Application Ref:	3/2026/0603			 Ribble Valley Borough Council www.ribblevalley.gov.uk
Date Inspected:	19/08/26	Site Notice:	19/08/26	
Officer:	LW			
DELEGATED ITEM FILE REPORT:				REFUSAL

Development Description:	Permission in principle application for two detached dwellings.
Site Address/Location:	Land adjacent to Fernhill, Ribchester Road, Clayton le Dale, BB1 9EG.

PROPOSED SITE PLAN
(Illustrative only)

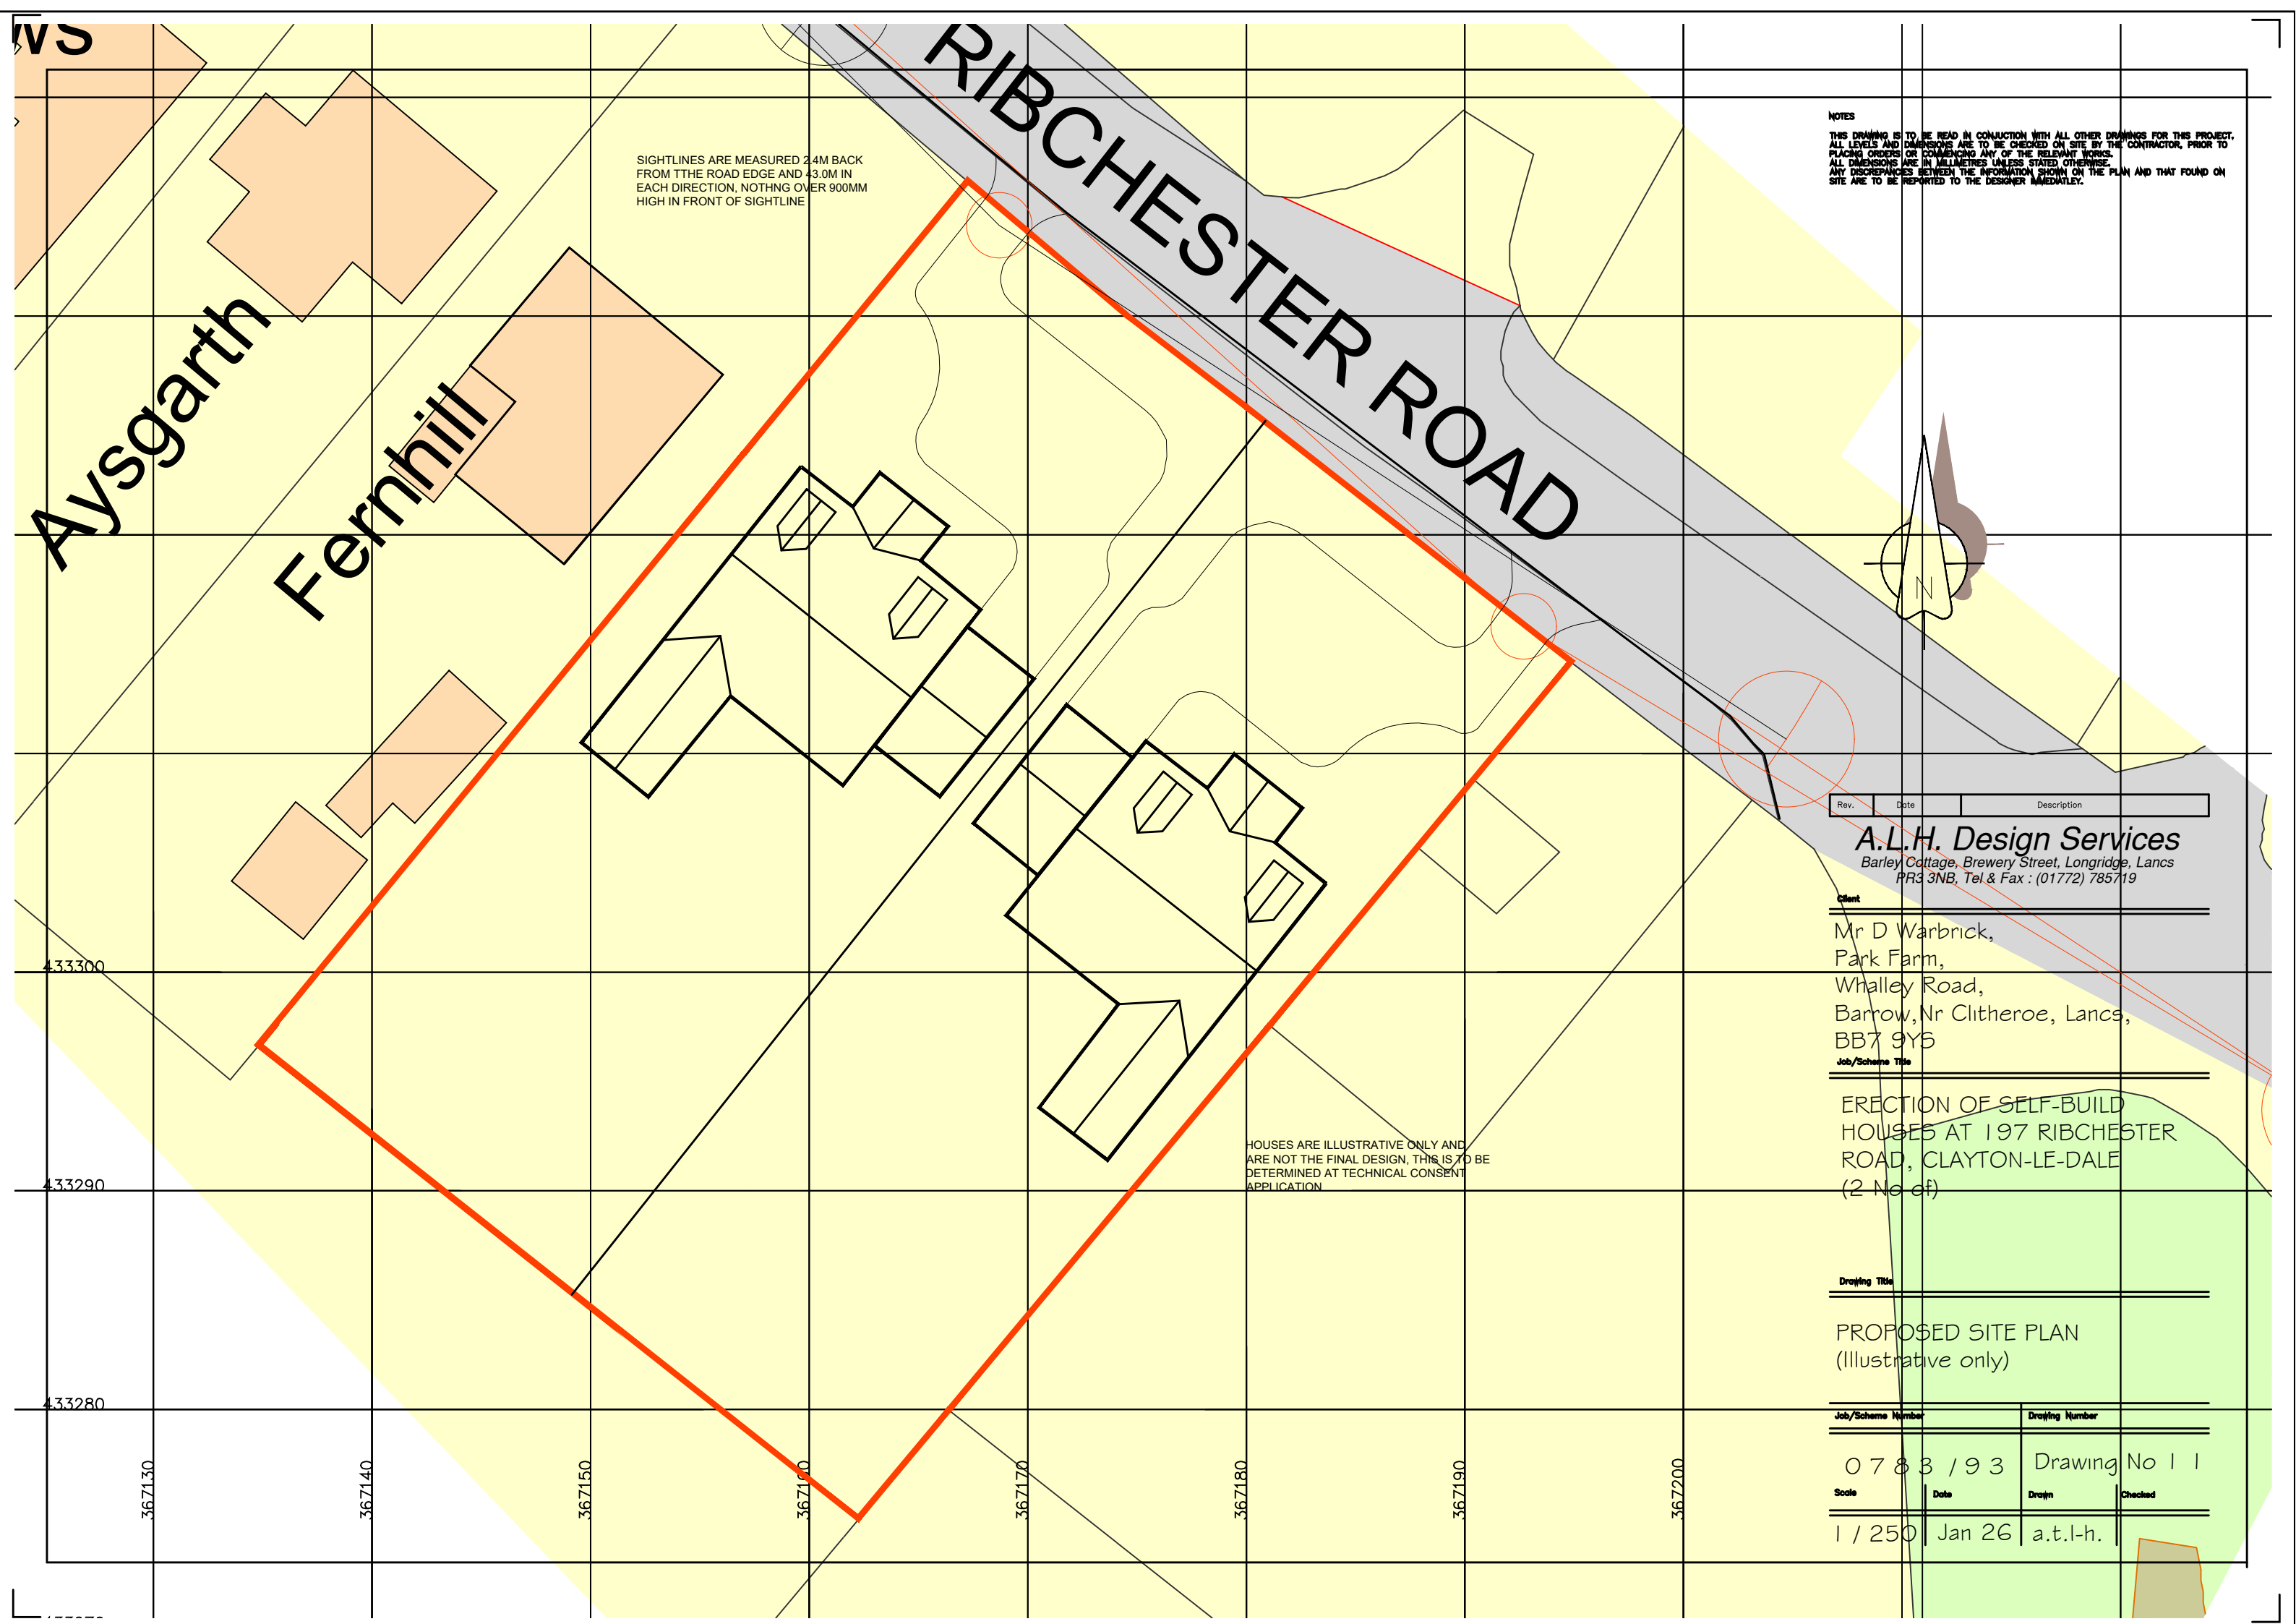
The indicative site layout submitted in support of the application demonstrates that the site is capable of accommodating two detached dwellings, together with associated parking and private amenity space. Whilst the layout is illustrative only, it provides a useful indication that the proposed quantum of development could be accommodated within the site without resulting in a cramped form of development.

PROPOSED SITE PLAN
(illustrative only)

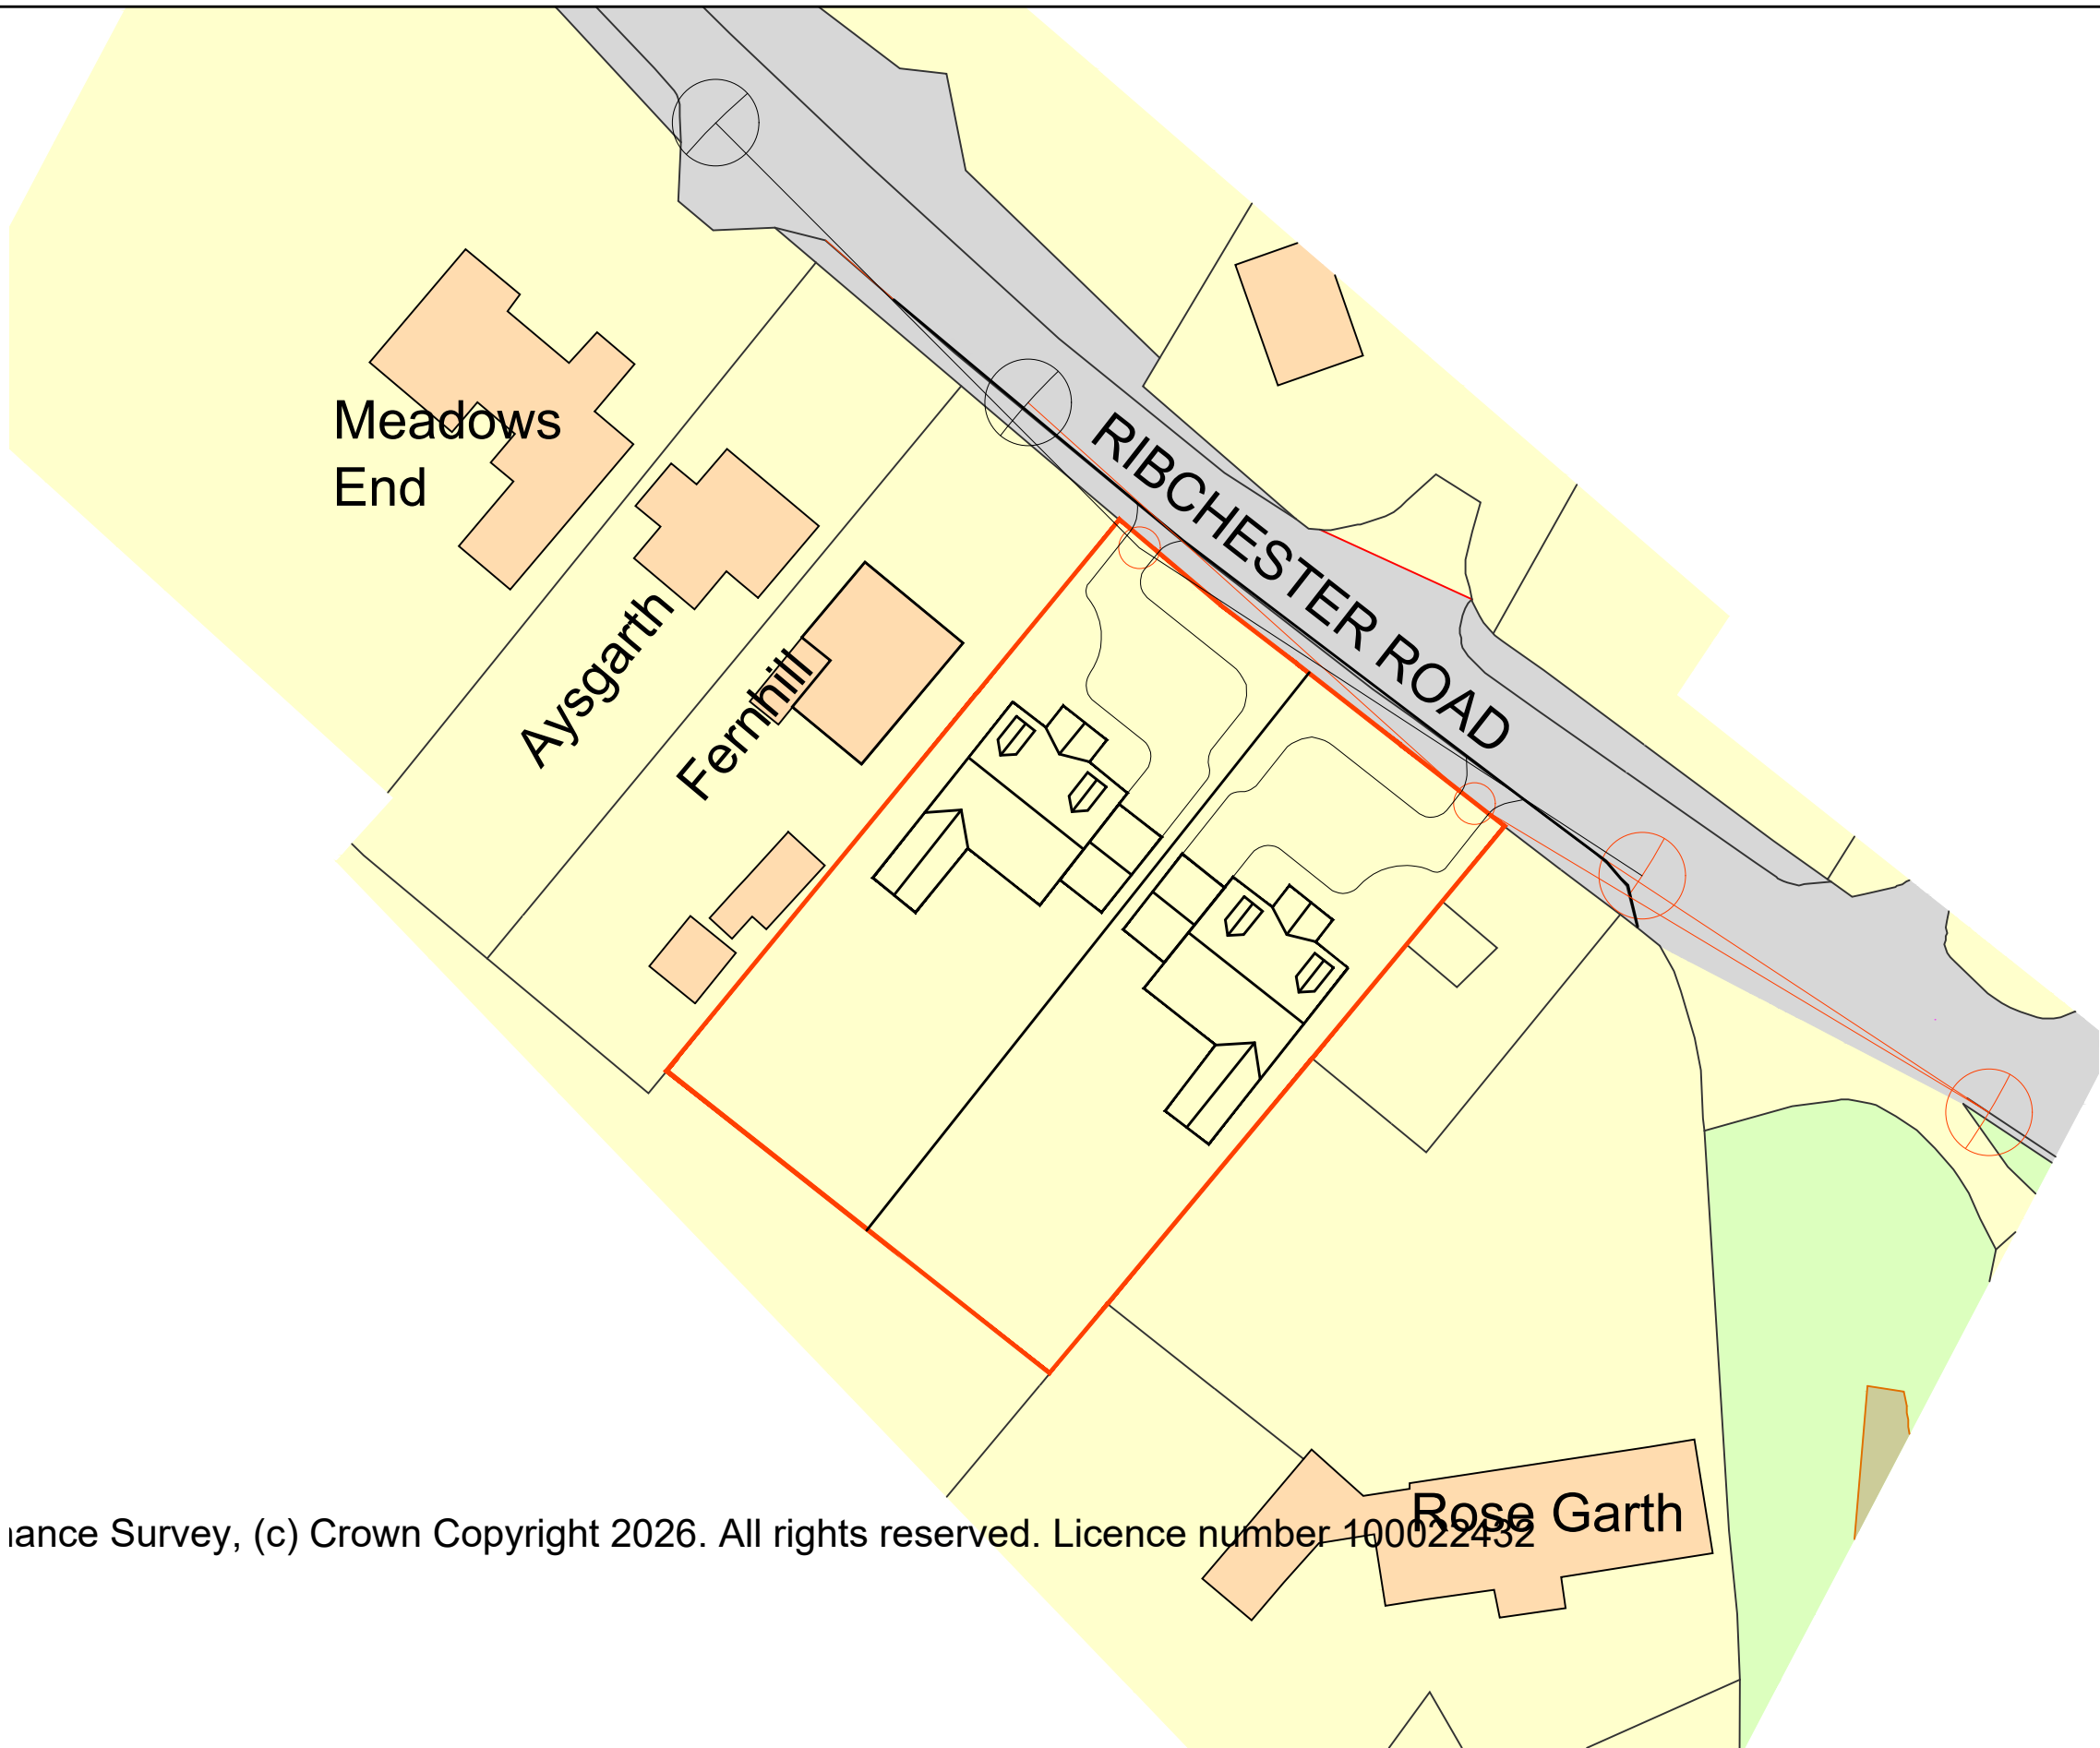
The site would be accessed directly from Ribchester Road, a classified two-way highway subject to a 30mph speed limit. The Local Highway Authority (LHA) advises that, for roads subject to a 30mph speed limit, visibility splays of 43 metres in both directions are required from each proposed access. These splays should be measured to the nearside carriageway edge of Ribchester Road and kept free from any obstruction exceeding 0.9 metres in height above carriageway level. The required splays must be contained wholly within

Having regard to the indicative site layout submitted, the Local Highway Authority considers that the required visibility splays cannot currently be achieved, as the visibility from both proposed access points would extend across third-party land. The LHA notes that the Proposed Site Plan is indicative only at this stage; however, unless suitable access arrangements can be achieved, potentially including the relocation of the proposed accesses, the Highway Authority advises that it would object to any subsequent Technical Details application where adequate visibility splays cannot be secured.

The Highway Authority has also advised that, should Permission in Principle be granted, a number of issues would need to be addressed at the Technical Details stage. In particular, the submitted indicative site layout shows a footway/verge of up to two metres in width along the site frontage. However, the Highway Authority considers this to be inaccurate and advises that revised plans should accurately identify the width of the service verge, together with the location of highway infrastructure, including surface water gullies and street lighting columns within and adjacent to the site frontage.

The submission of site sections and cross-sections is also recommended in order to demonstrate how suitable vehicular accesses can be achieved, having regard to the difference in levels between Ribchester Road and the application site, which rises away from the highway. Any proposed access arrangements would need to ensure that driveway gradients are acceptable and do not prejudice highway safety. In addition, the first five metres of each access, measured from the rear edge of the highway verge, would need to be surfaced in a bound material to prevent loose material being deposited onto the highway. Appropriate drainage measures would also be required to ensure that surface water is collected within the site and discharged to a suitable outfall, thereby preventing runoff from entering the public highway.
